10682 Banbury Oil Deport

Technical Note 5: Response to EA Drainage Comments 16th January 2023

8th March 2023

Figure 7-1: Flood Depths - Defended 0.1% annual probability (1 in 1000 year) event – Station

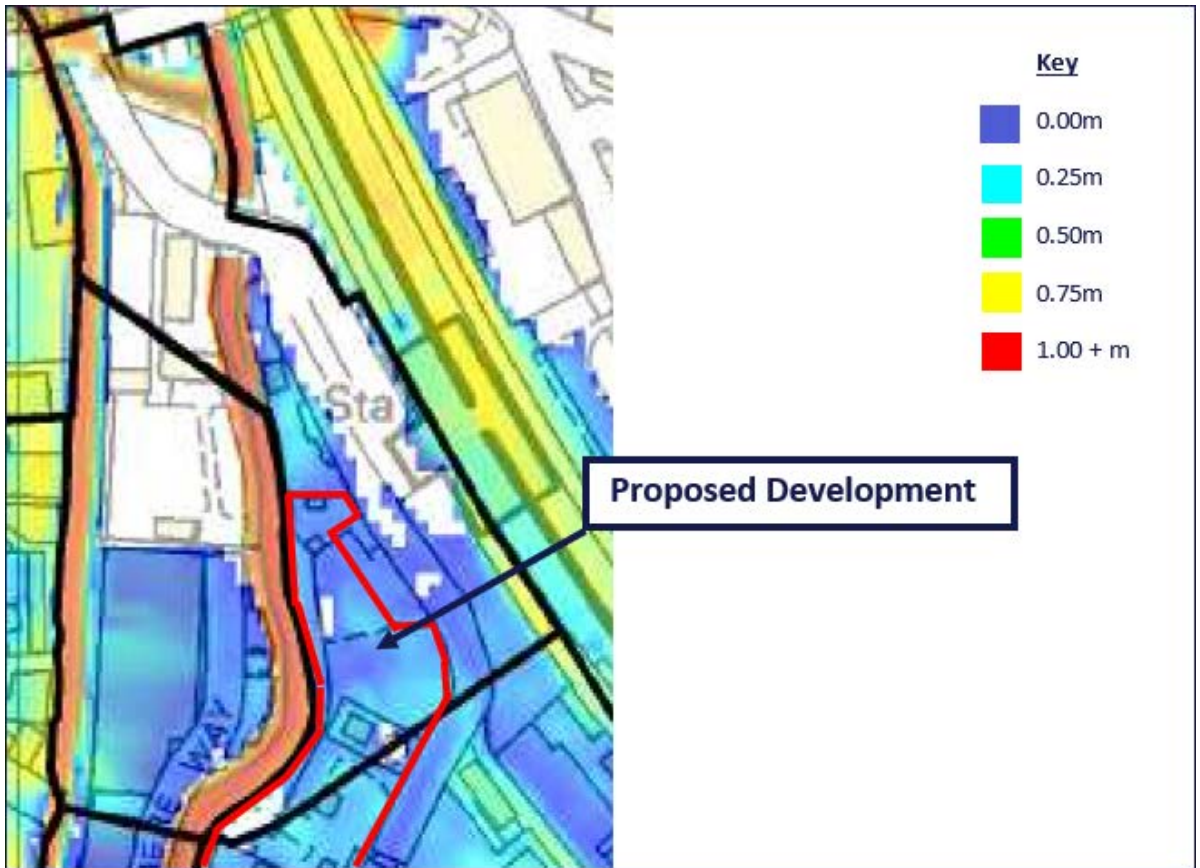
- 2.1 *The applicant has not provided details of any of the other climate change scenarios for this catchment and to proceed with detailed designs based on this extreme representation of flooding is unlikely to result in a viable development. The applicant needs to also consider the higher central climate change scenario (25%). Should this result in increased flood risk to the nearby rail station and tracks, compensation to address this will need to be designed and shown to be feasible in order for planning permission to be granted. Should the rail station and be unaffected by the development proposal using the 25% scenario, then it may only be necessary to consider the central climate change allowance of 15%.*

- 2.2 The EA's model has now been run to illustrate the 25% climate change scenario and 15% climate change scenario, with the modelled results provided in **Appendix A**. Due to the extent of flooding across Banbury, in both scenarios the development Site is still affected by flooding coming in from the railway line.

- 2.3 The maximum flood depths across the Site are:
 - 1 in 100 year plus 49% climate change storm event - 0.4996m
 - 1 in 100 year plus 25% climate change storm event - 0.406m

- 1 in 100 year plus 15% climate change storm event - 0.346m
- 2.4 The application Site forms part of an allocated site under Planning Policy BAN1 Banbury Canalside. The Site is also protected by the Banbury Flood Alleviation Scheme, the model has also been run in the defended scenario. Modelled results provided in **Appendix B**. As shown in these results the proposed development blocks are unaffected by flooding in the 1 in 100 year, 1 in 100 year plus 15% climate change, 1 in 100 year plus 25% climate change and 1 in 100 year plus 49% climate change storm events.

2.5 Therefore, as the development Site is protected from flooding in the defended scenario, flood compensation from the development is not required. However, as the Site is affected by 0.4996m of flood water during the undefended scenarios, flood resilient building techniques could be included in the ground floor areas of the development. These measures would be secured by a planning condition and could include, but are not limited to:
